Our ref: Q230249
Your ref: 20/04145/FU
Email: sean.rawling@quod.com
Date: 22 November 2023

Town and Country Planning Act 1980 (as amended)
Section 96a and Section 73 Applications Pursuant to Planning Permission
Reference 20/04145/FU
Foundry Street / Saxton Lane Former, Leeds

Please find enclosed a Section 96a (S96a) and Section 73 (S73) application on behalf of Wakefield and District Housing Ltd (the “Applicant”) pursuant to planning permission 20/04145/FU (the “Consent”) at Foundry Street / Saxton Lane, Leeds (the “Site”).

- **Section 96a:** seeks non-materials amendments to the elevations and an extension of the stair core at from levels 17 to 19.
- **Section 73:** seeks consent for an additional three affordable units in place of the first floor amenity space.

Proposed East West Elevations

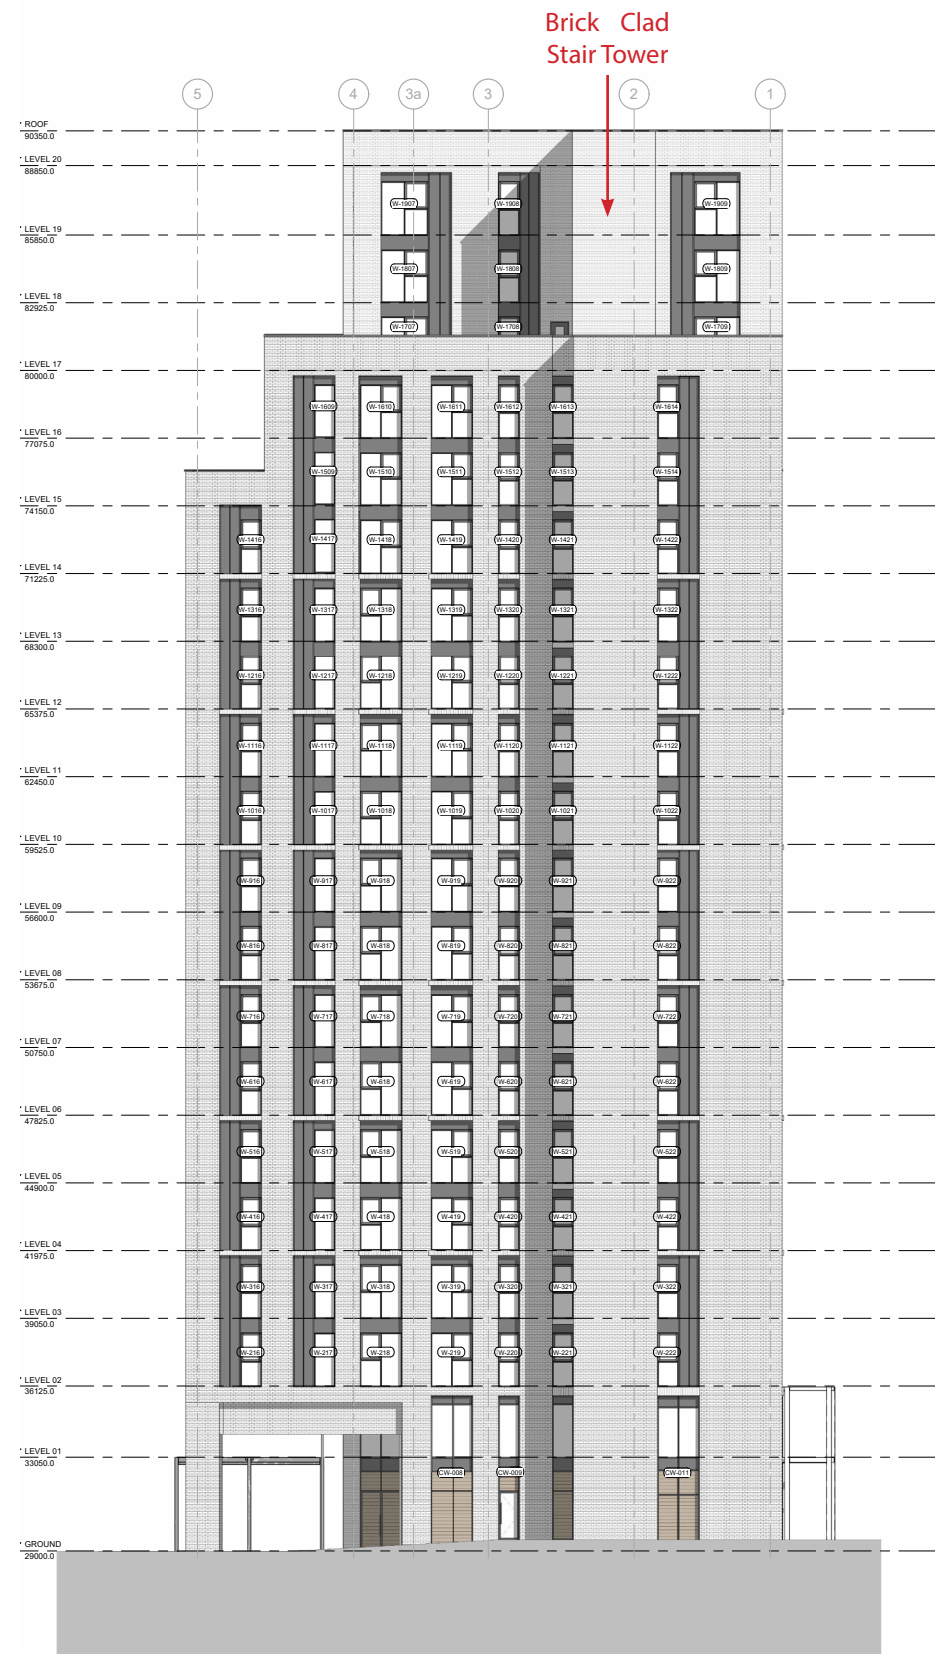
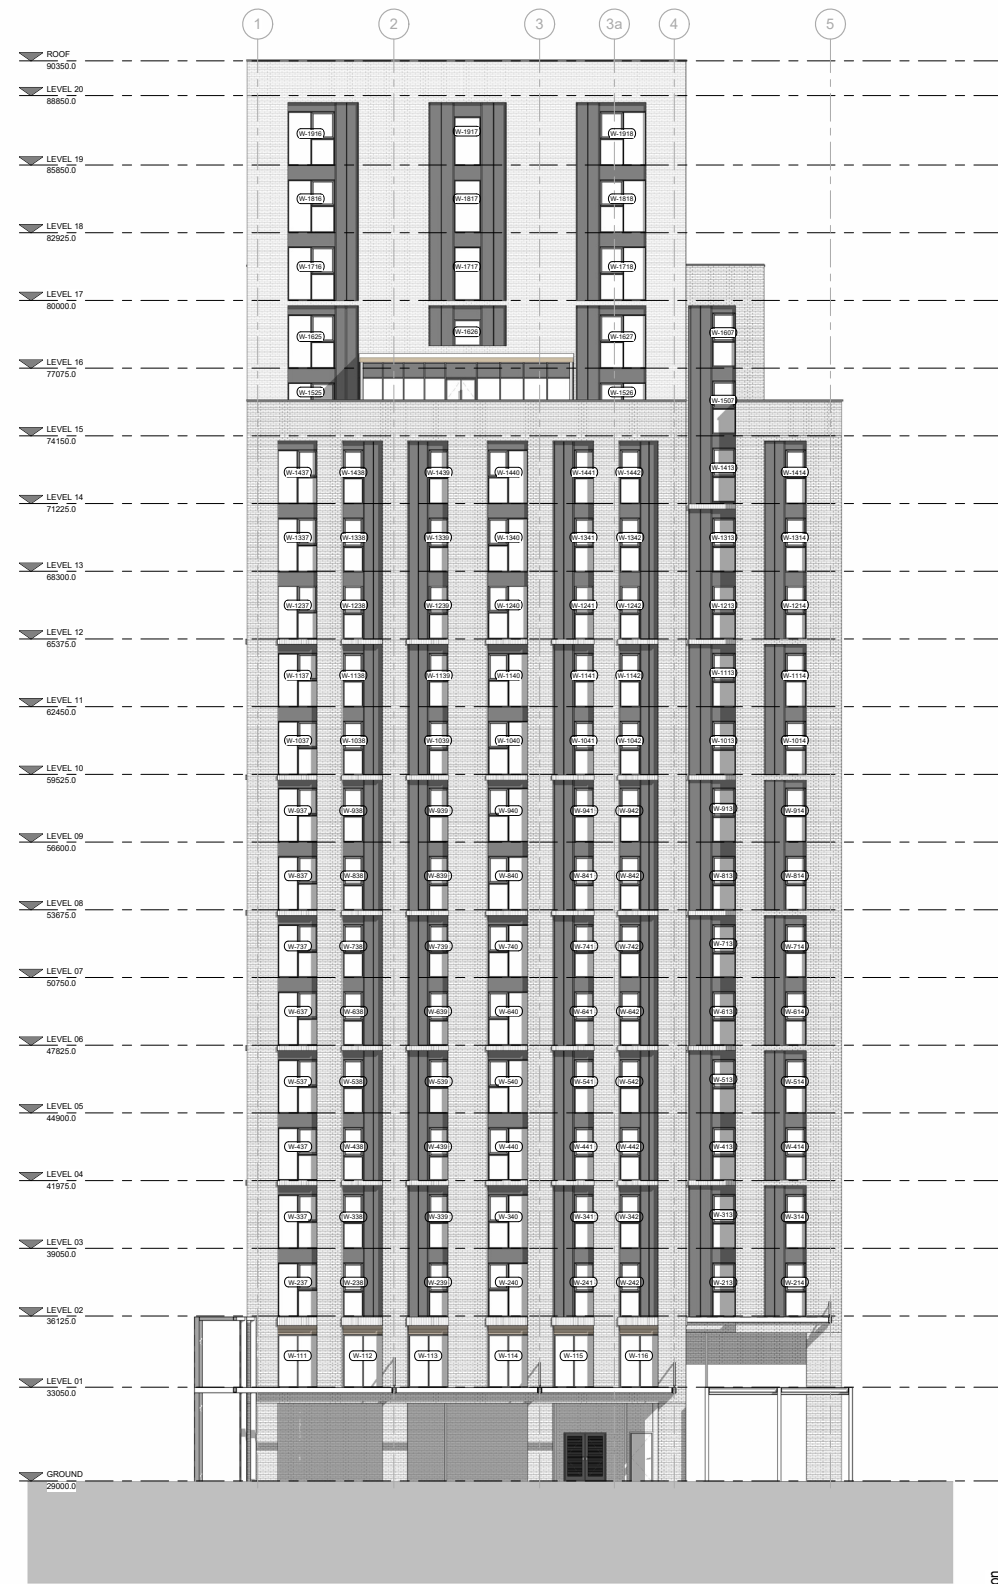
- Shift of proposed entrance.
- Extension of bike store to allow for 207 spaces.
- Additional fire escape door along eastern elevation for second stair core.
- Shift of windows between living space and bedroom to allow for wider window to living spaces at levels 2 to 19, along central spine of the northern and southern elevations.

In terms of design and appearance, the remaining external and internal alterations to the building are negligible. The change to the entrance door, inclusion of a new fire escape door, and shifting of the bedroom and living room windows have no discernible effect on the design and appearance of the proposals, particularly when considered in the context of the wider development.
